HINCKLEY NATIONAL RAIL FREIGHT INTERCHANGE

Project reference TR050007

Applicant's Response to Deadline 4 Submissions [part 8 – Parish Councils]

9 February 2024

Note: To be read in conjunction with the Access and Rights of Way Plans (document reference: APP-017 to APP-020) and the Public Right of Way Appraisal and Strategy (document reference: 6.2.11.2)

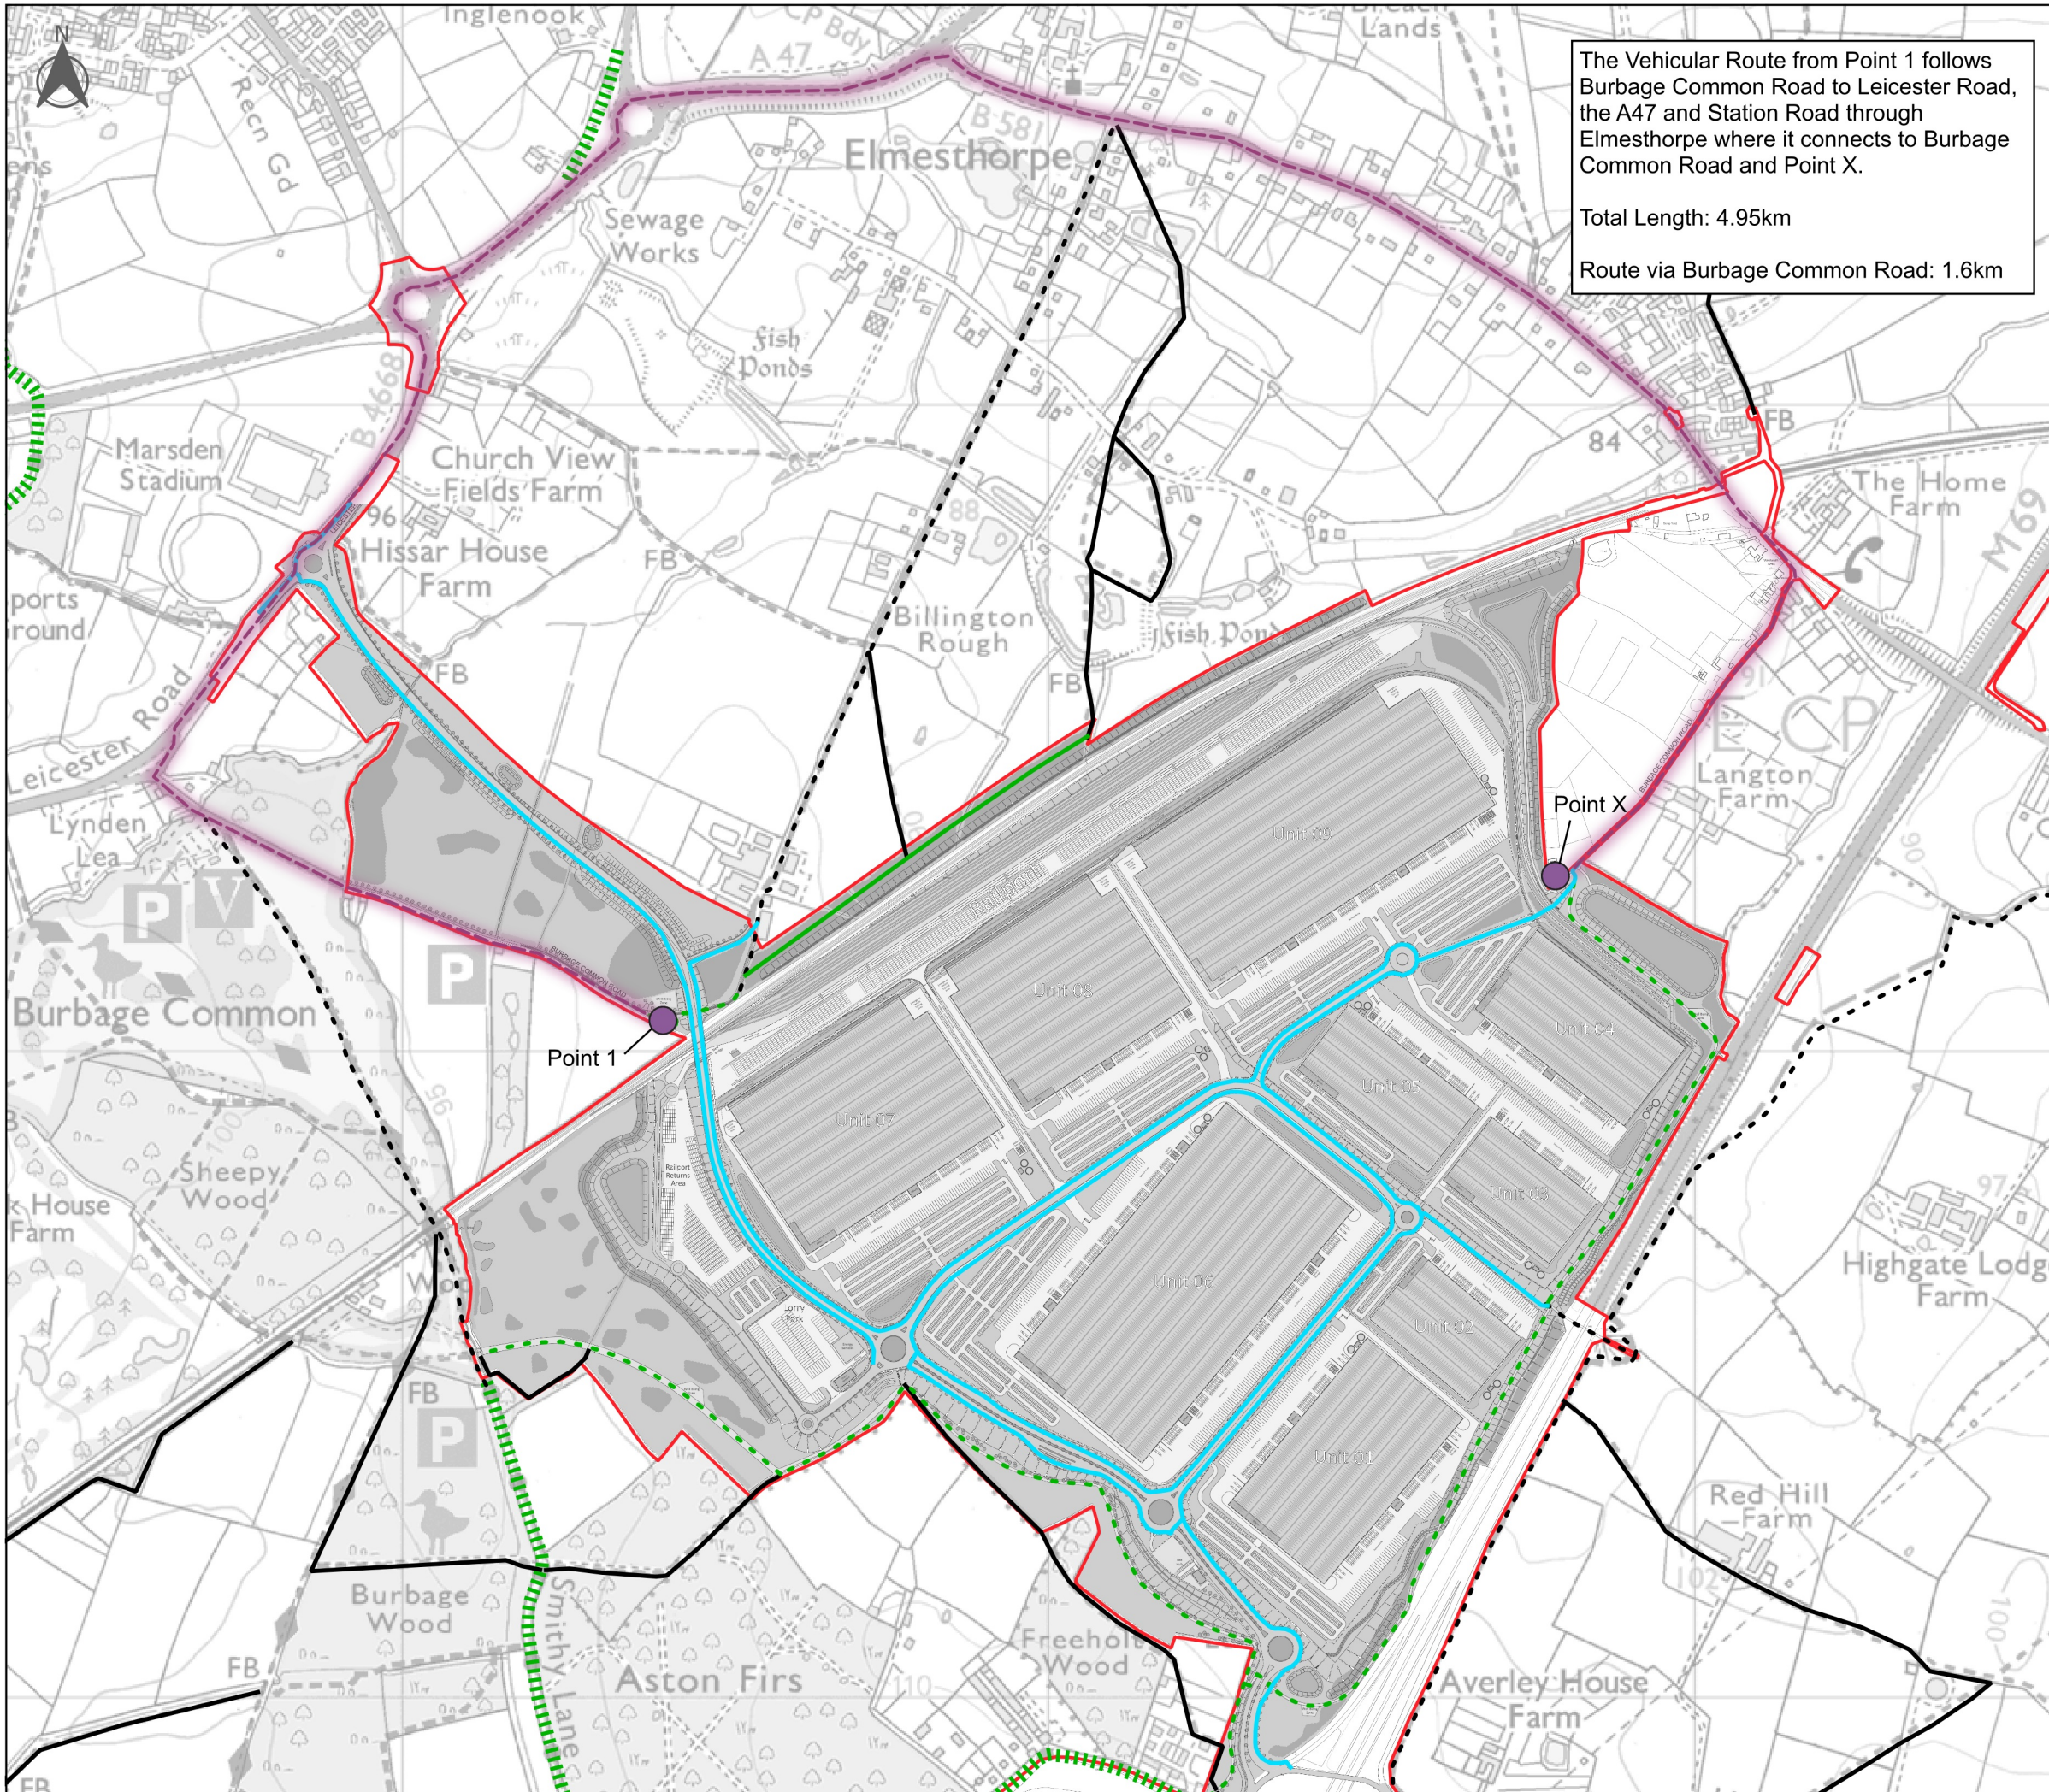
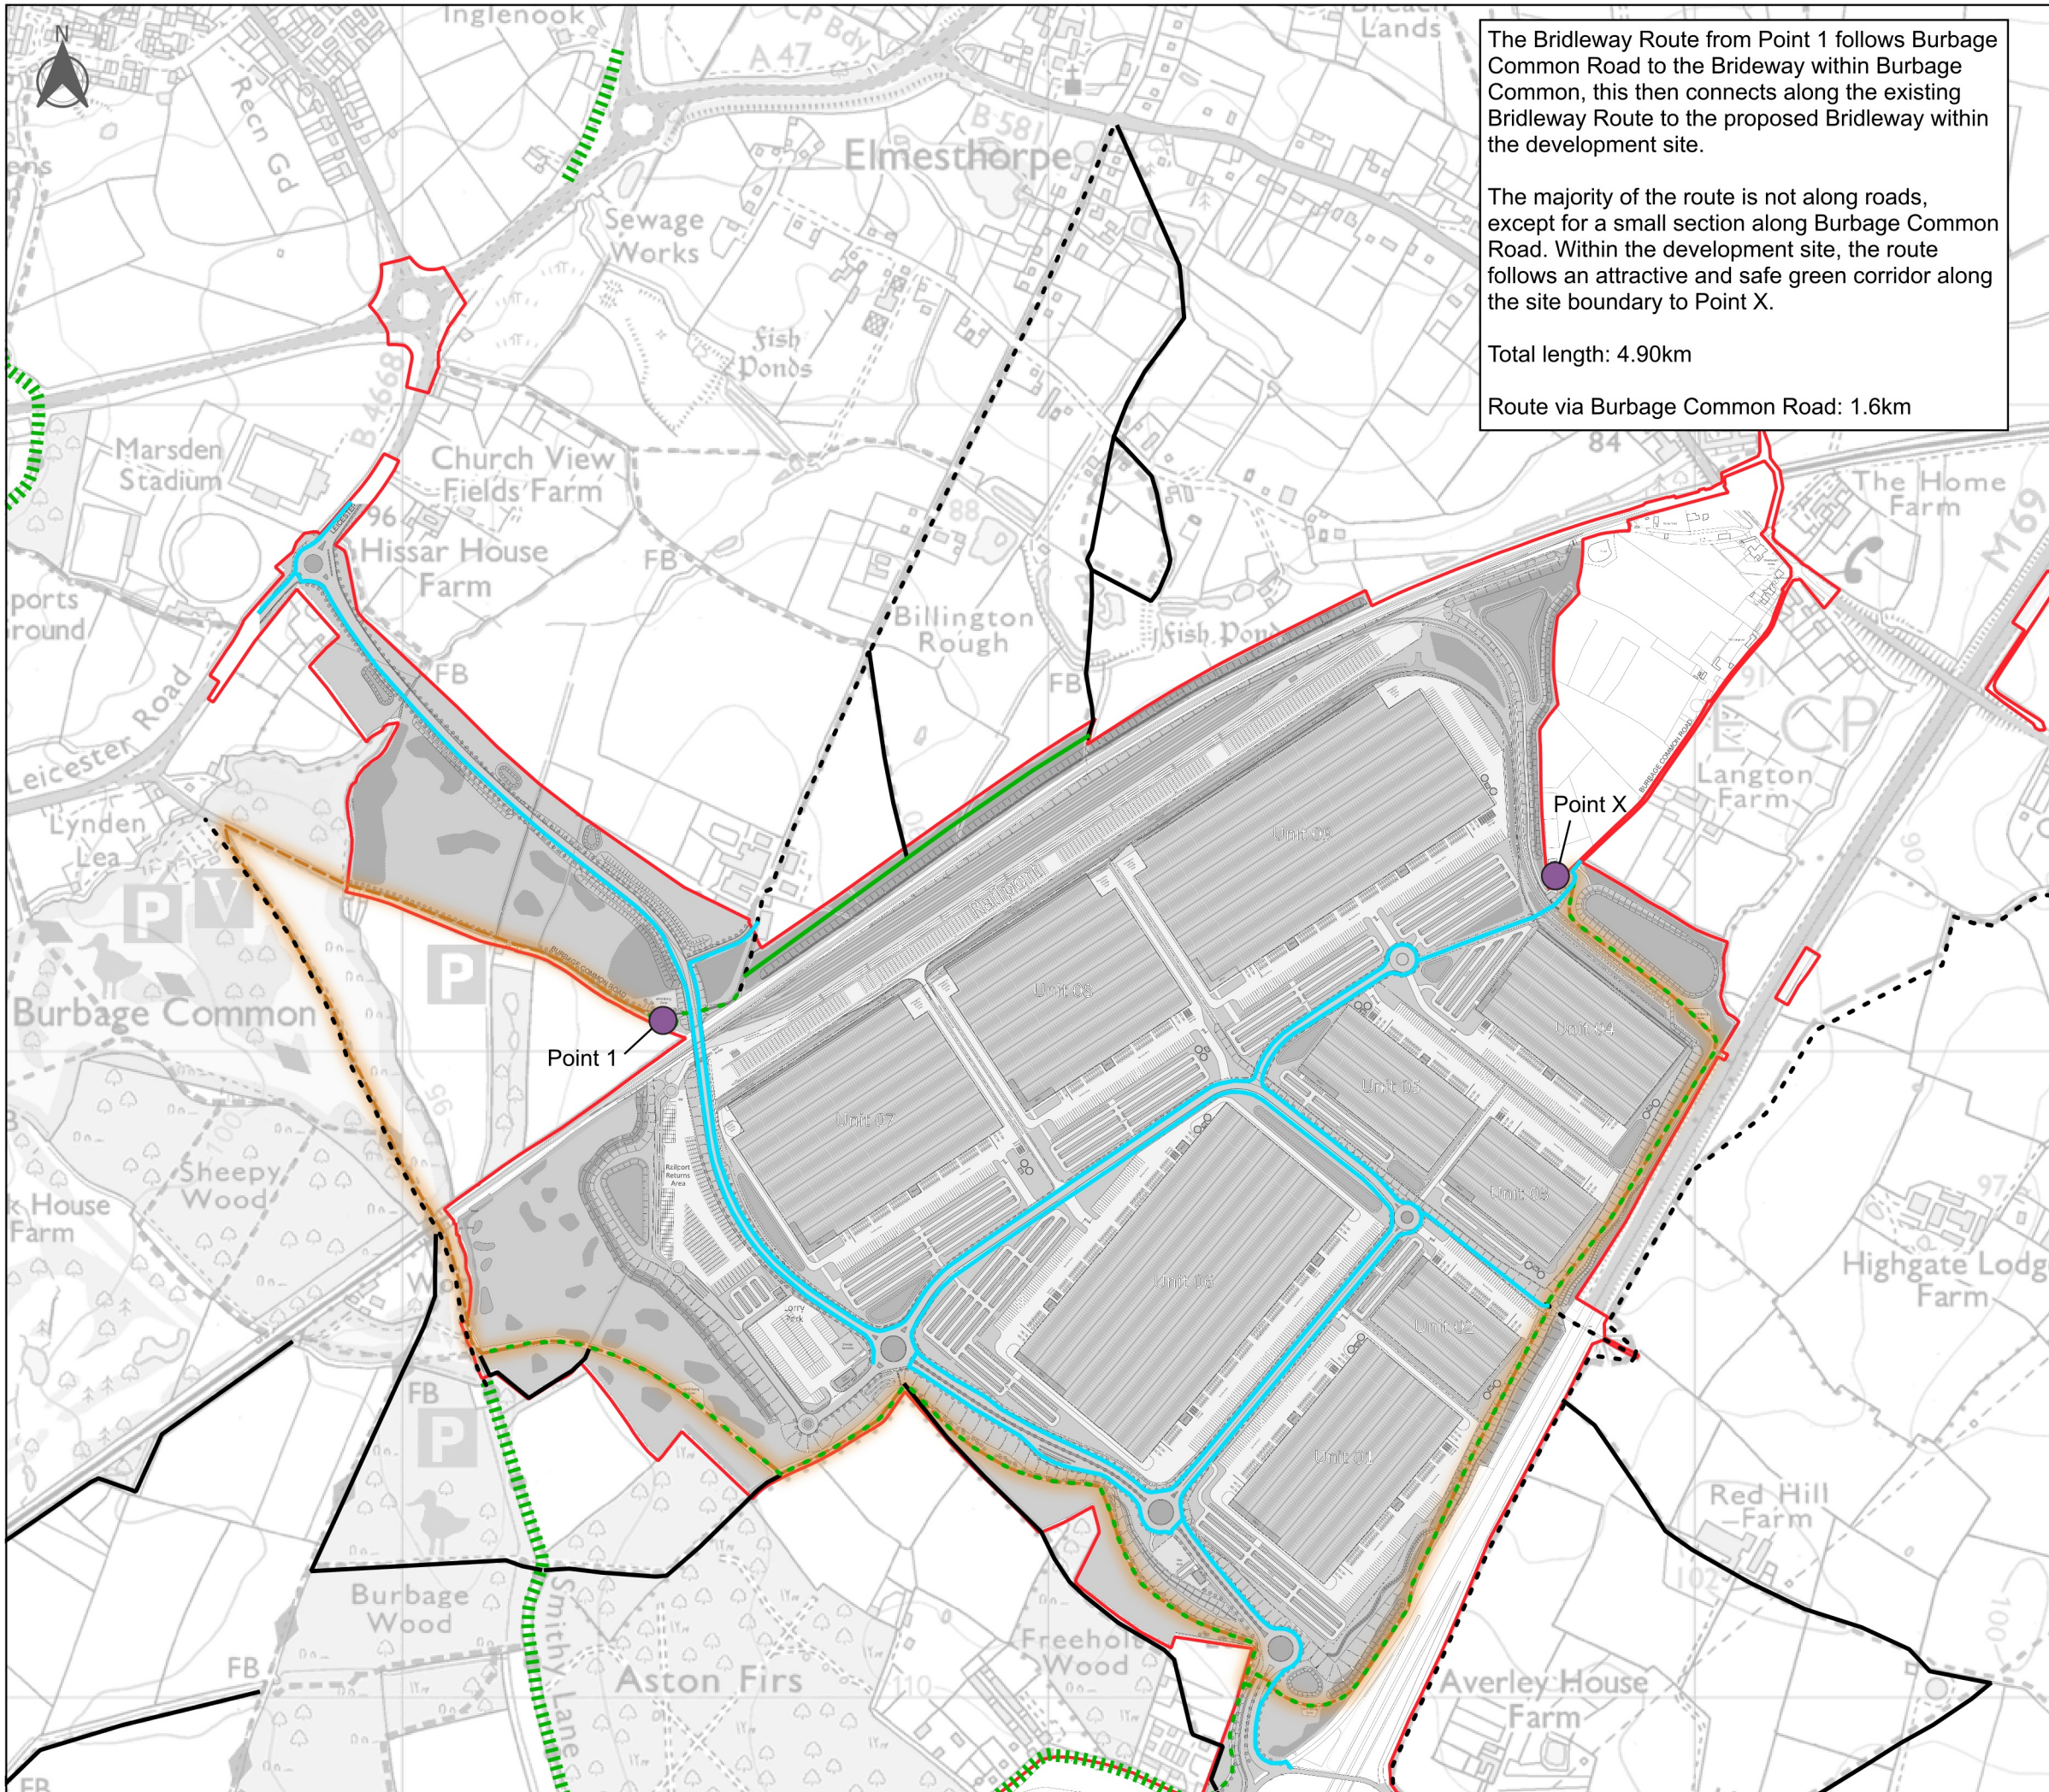
2	1.11.32	<p>Effect on users of Burbage Common Road</p> <p>In the response dealing with the distances between points 1 and X on the Access and Rights of Way Plan (2.3A and 2.3B), the Applicant has referred to users being able to use permissive ways (comment in 'Alternative route' for Walkers in [REP3-054]. b) Could the Applicant please explain how, in line with paragraph 5.216 of the NPSNN, the routes and measures being secured would meet the strong</p>	<p>Burbage Common Road is the main link from Elmesthorpe to the beloved Burbage Common and Woods SSSI (including Elmesthorpe Plantation). Many residents use this road to walk for leisure, or to exercise their dogs/other animals. Burbage Common Road, whilst it is a road accessible for vehicles, is mainly used for access to business on Burbage Common Road, agricultural vehicles, as a bridlepath for equestrian users or by those with mobility scooters/wheelchairs/prams to access Burbage Common or enjoy the surrounding countryside, without having to traverse alongside the very busy A47/B4668 or along</p>	<p>The route between points 1 and X identified for cyclists, to the south of the railway bridge (the majority of its length) will be lit. The effects of this are considered in the environmental assessment. Lighting for security purposes will be provided within the new underpasses. It should be noted that the proposed route between points 1 and X provides a higher quality route than at present as it is segregated from vehicular traffic and well illuminated for the majority of its length contrary to Burbage Common Road. At the A47 link road/B4668 junction, a crossing point is provided between the shared footway cycleway on the link road and the shared footway/cycleway</p>
